Your ref: 3/2020/0507
Our ref: DC/20/3071
Date: 14-OCT-20

Location: Land South of Blackburn Road Hothersall PR3 2YY
Proposal: Business Units Use Classes B1 (b) (c) and B2 and Storage Use Class B8 and associated improvements

United Utilities Assets and Infrastructure - OBJECTION

Land south of Lower Road, Longridge – Indicative layout

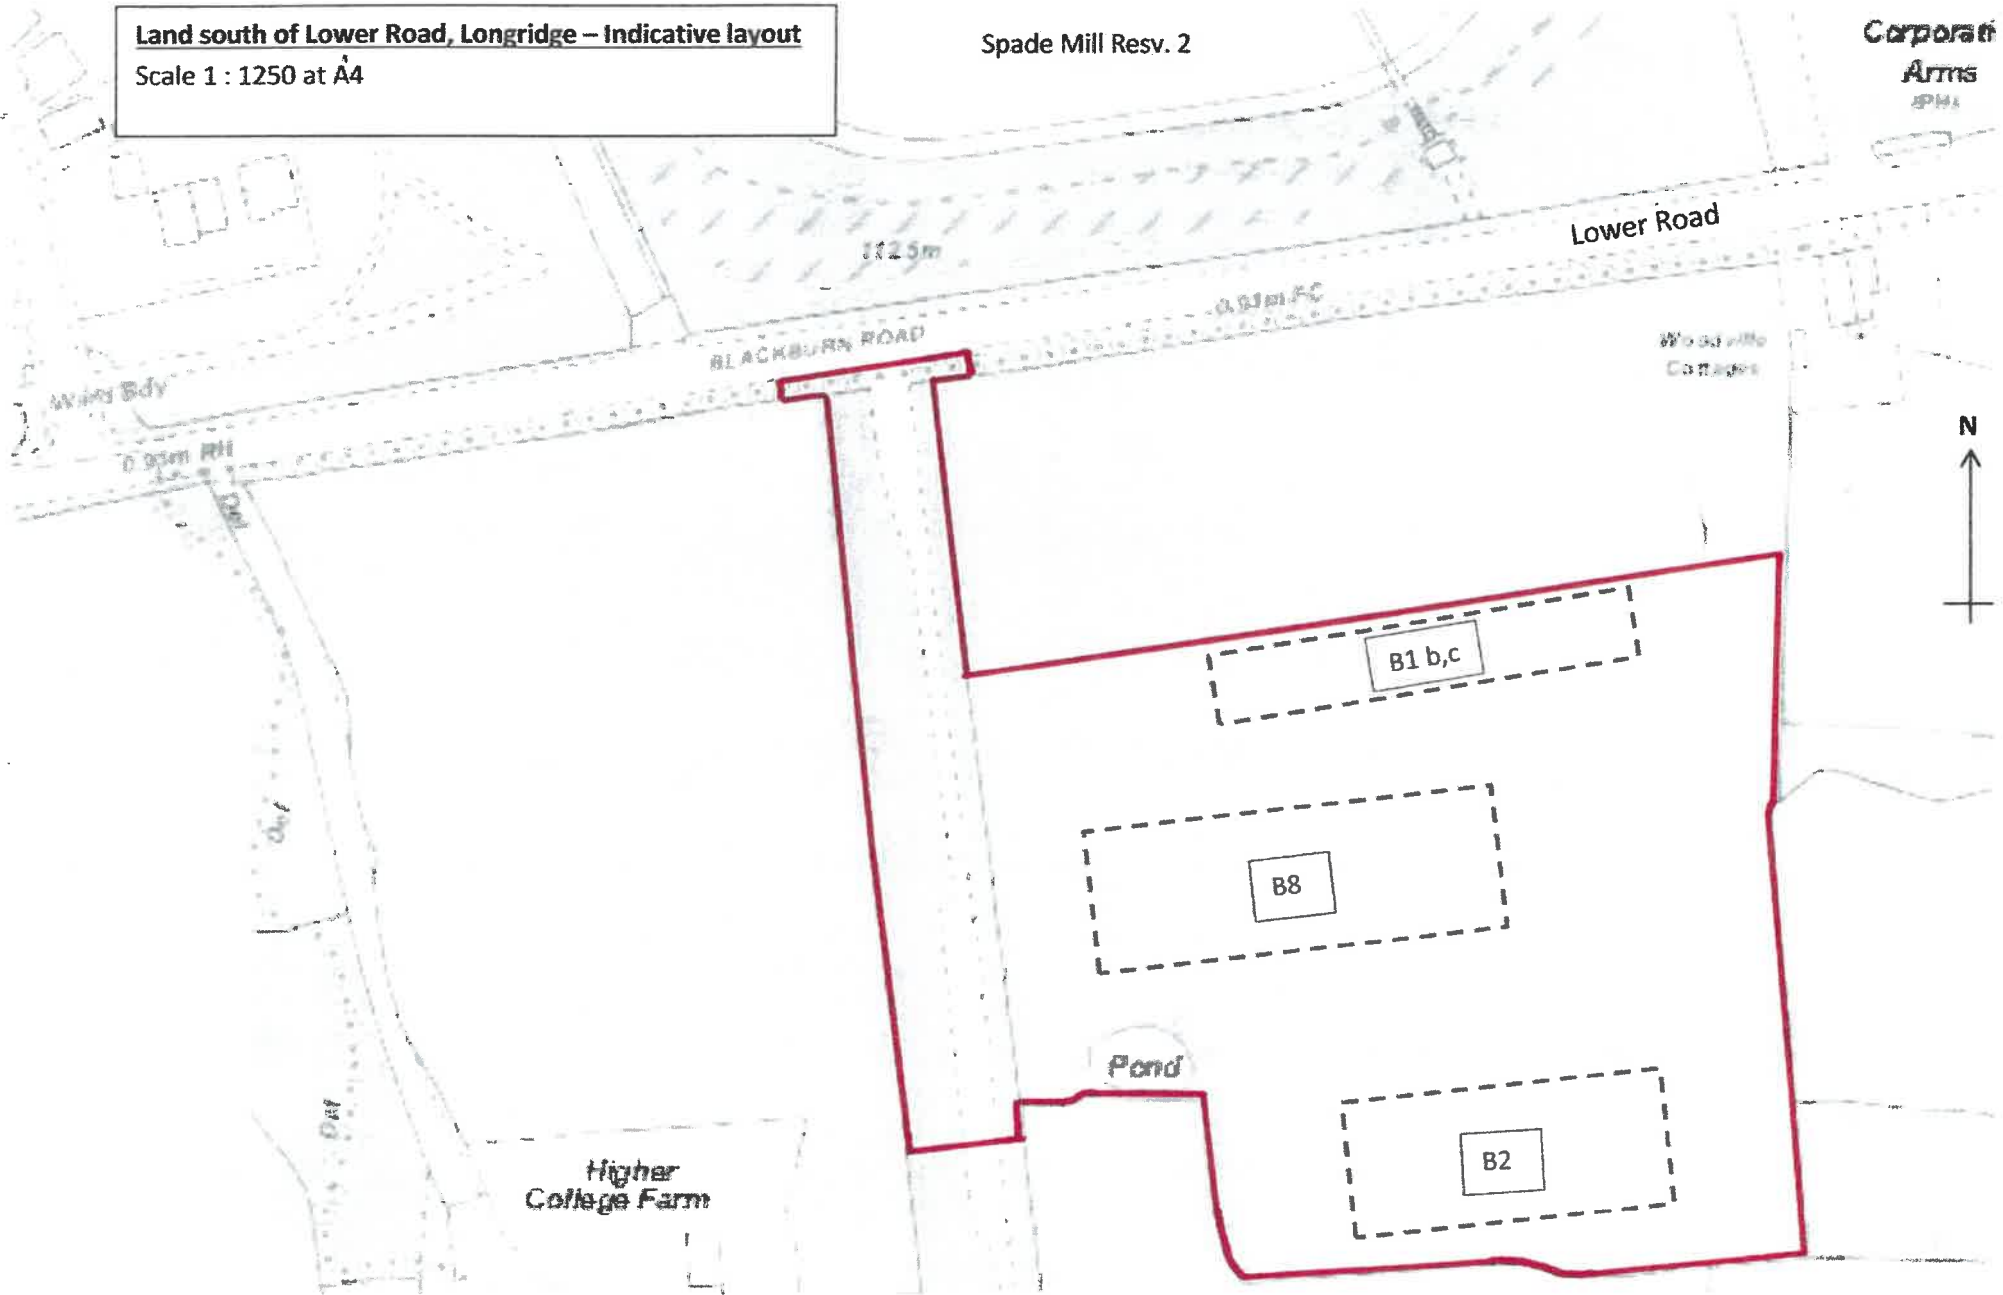
The applicant should be aware that a large Raw Water Distribution Main crosses the site of the proposed development. United Utilities will not permit building over or in close proximity to this asset. Our current position is that we must OBJECT to this proposal until proximity of the proposed development to this asset is fully investigated.

The raw water main is still in service. We would want the applicants to review their plan to ensure that the easements are observed.

As we need access for operating and maintaining water mains, we will not permit development in close proximity to the main and will require an access strip either side of the centre line of the pipe.

This should be taken into account in the final site layout, or a diversion may be necessary. Both during and post construction, there should be no additional load bearing capacity on the main without prior agreement from United Utilities. This would include earth movement and the transport and position of construction and agricultural equipment and vehicles.
